Application no.: 3.2023.610

Proposal: Proposed demolition of existing garage and construction of a two-storey rear and side extension, new dormer to existing roofslope to (south) side elevation, and a two-storey annex at the end of the rear garden.

Location: 13 Clitheroe Road Whalley BB7 9AA

The submitted documents and plans have been reviewed and the following comments are made.

PROPOSED SITE PLAN

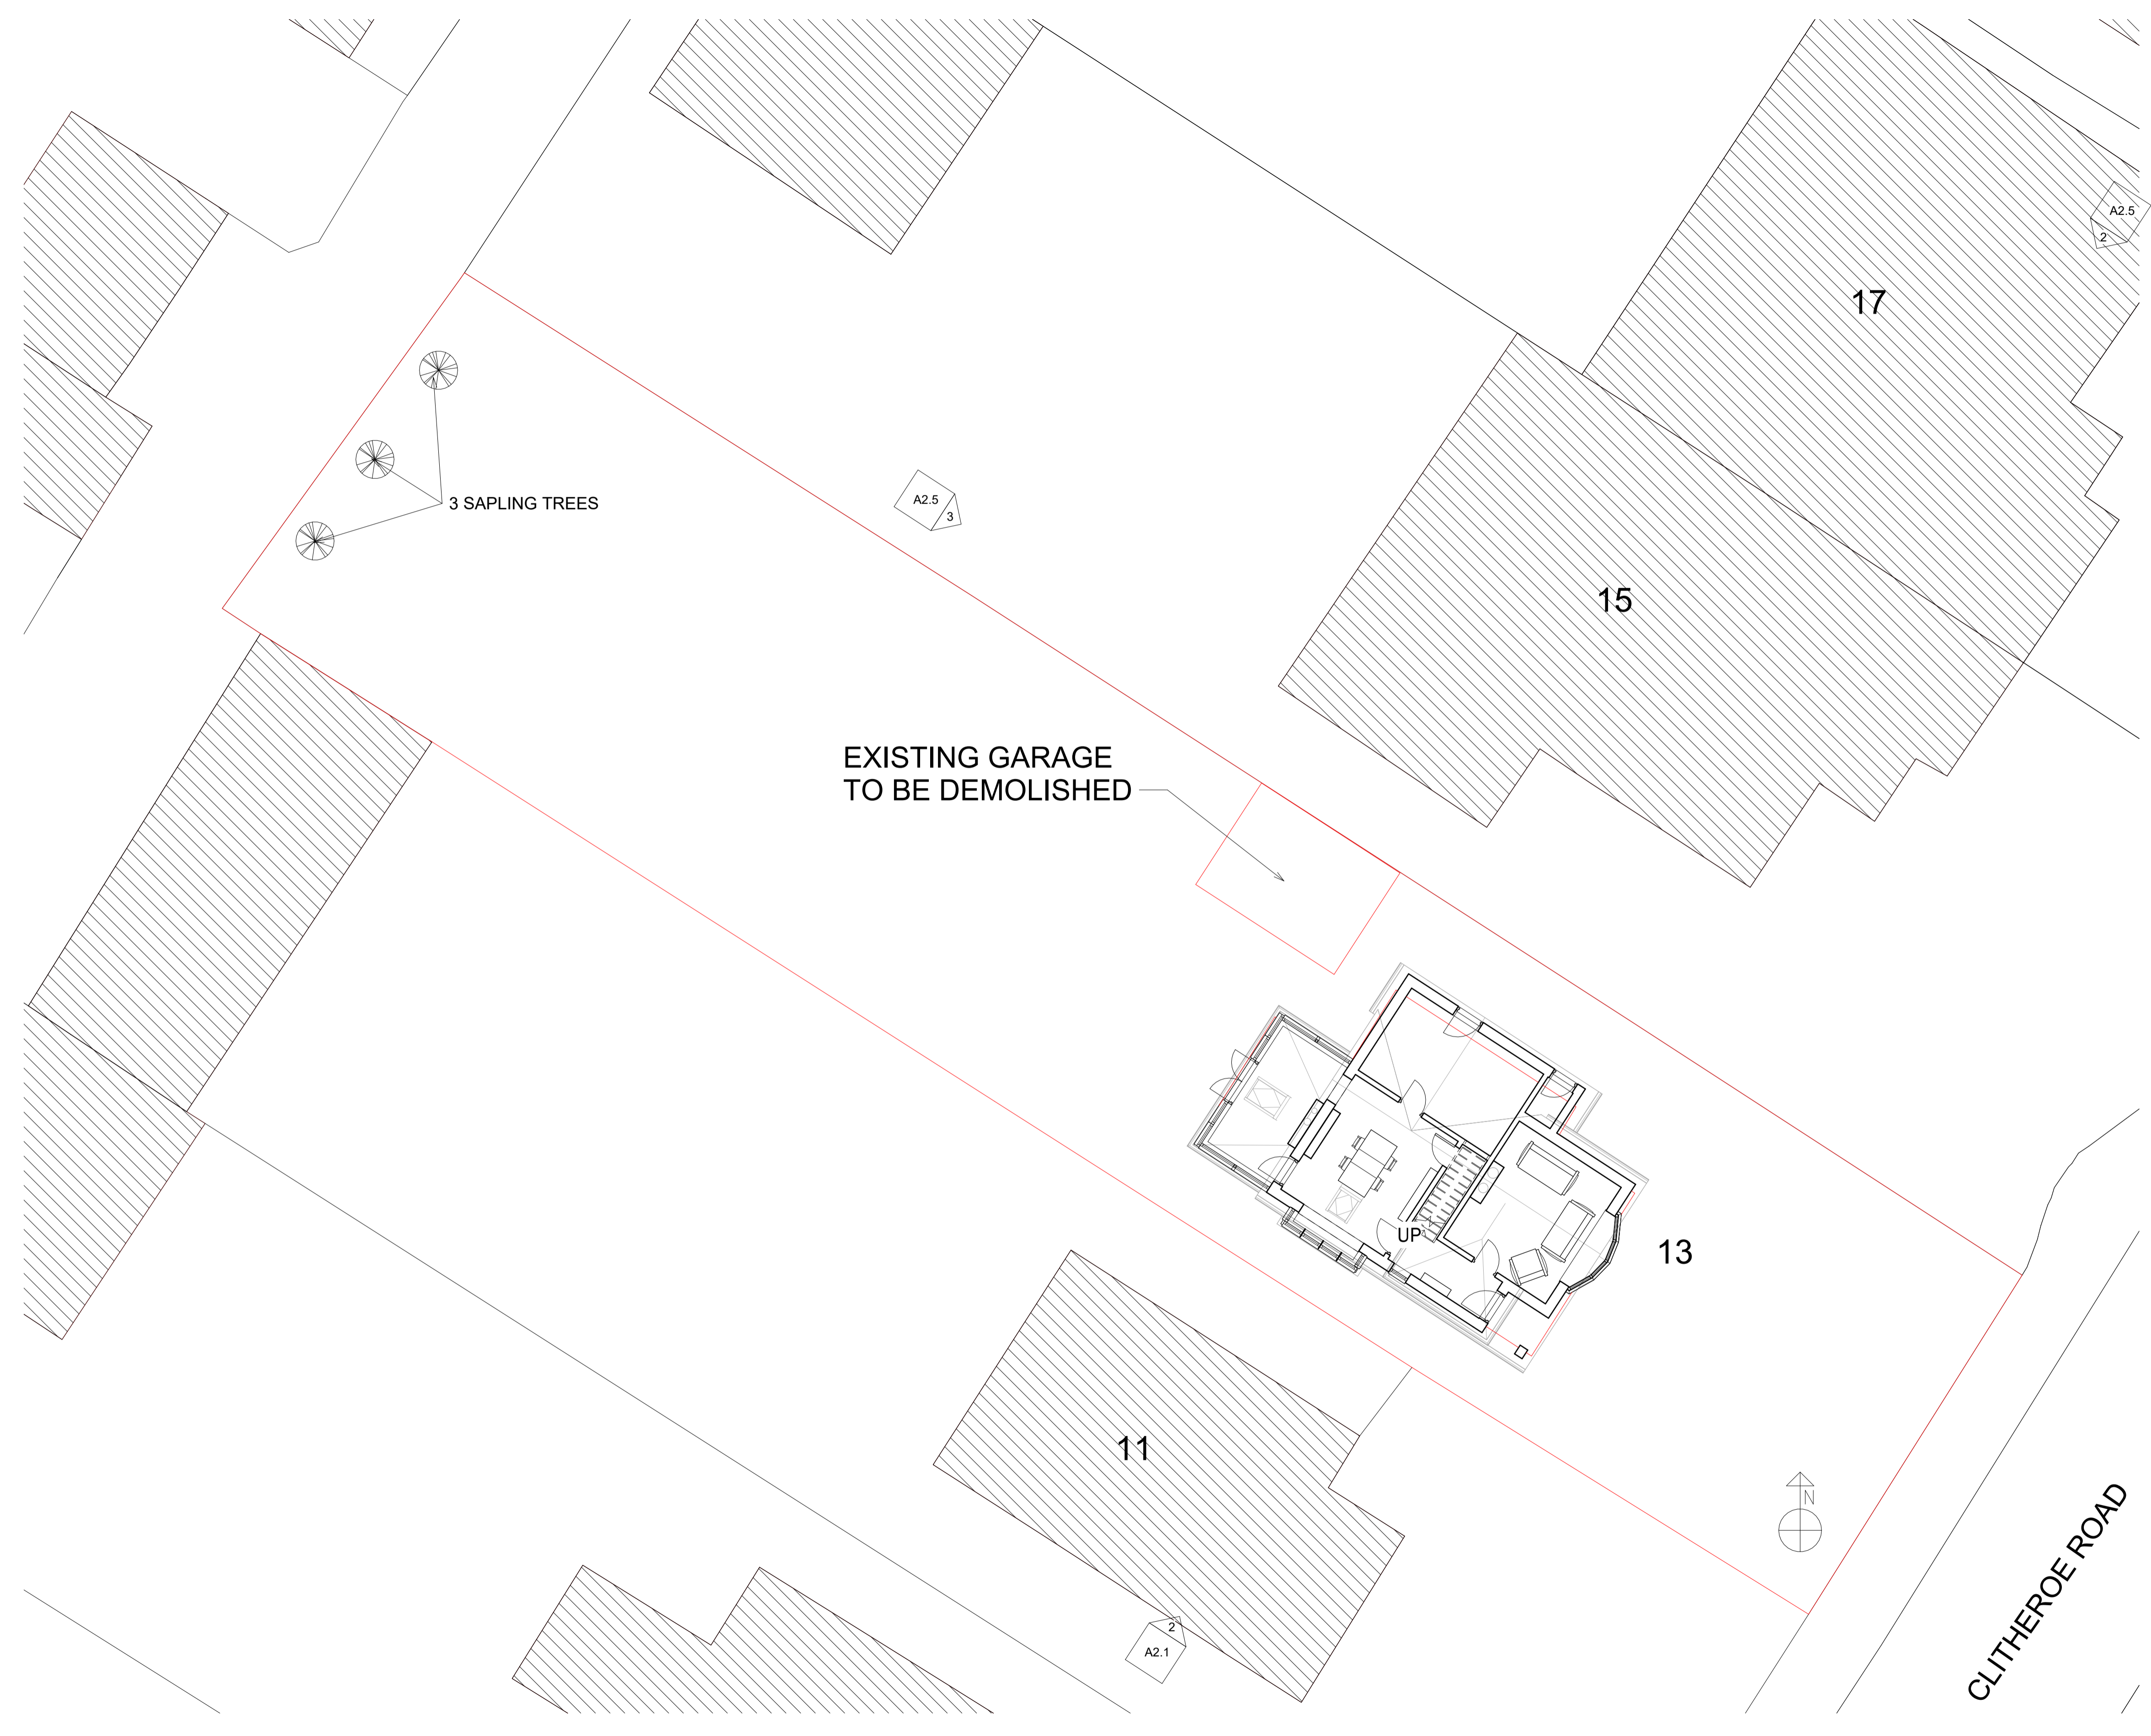
There is a loss of a garage with this proposal. No parking plan has been submitted.

Providing parking standards requirements can be met for this size of property within in the curtilage ie 3 parking spaces (2.4m x 4.8m in size each) for a 4+ property, then there is no objection to this proposal.
